DEVELOPMENT REVIEW BOARD
TRANSPORTATION DEVELOPMENT

DRB Project Number: 1011573
Atrisco Business Park Unit 2

SUBJECT: Site Plan for Building Permit

DRB Project Number: 1011573 Hearing Date: 04-18-2018
 Project: Vitality Works Agenda Item No: 6

SHEET TITLE:
SITE PLAN
FOR BUILDING
PERMIT

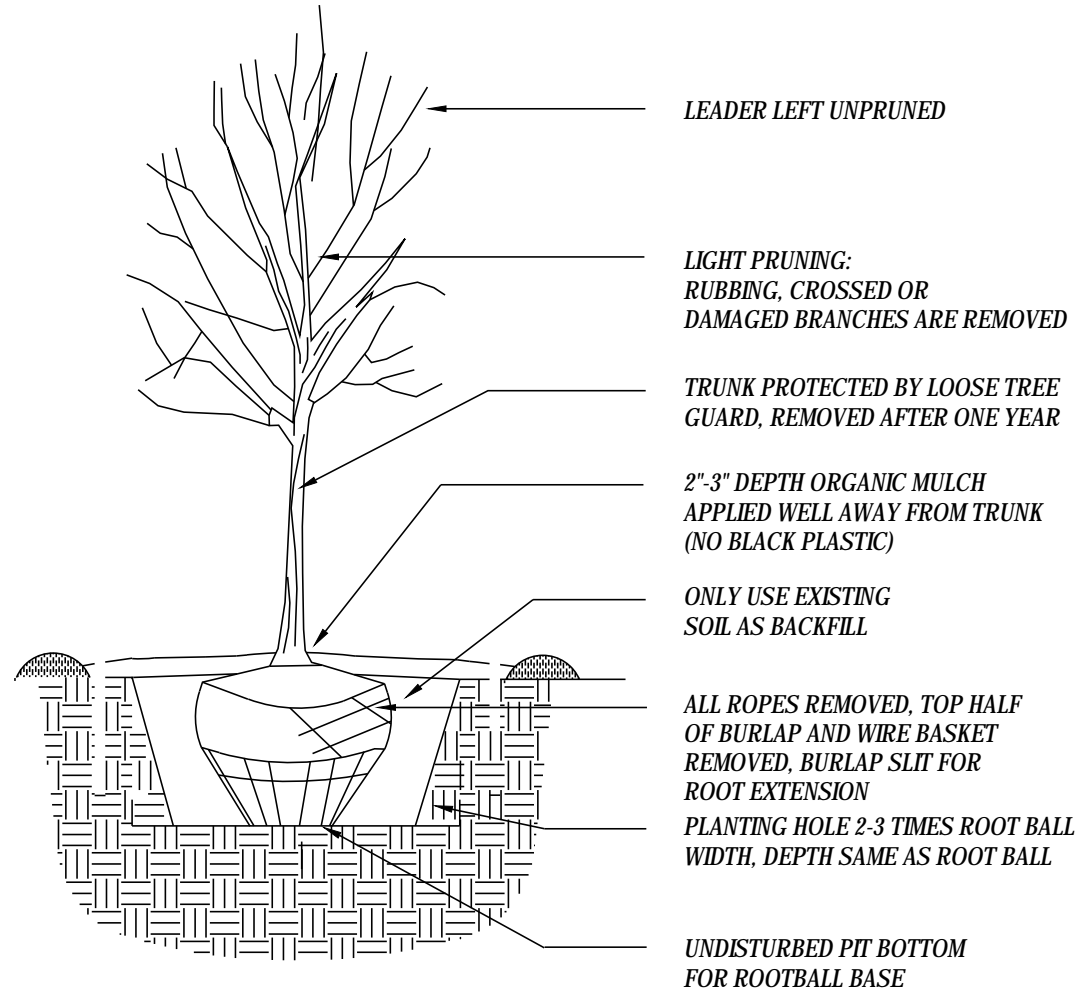
1. Provide public sidewalk easement for portion of sidewalk not in the right of way. This can be provided prior to C.O.

↳ has been submitted
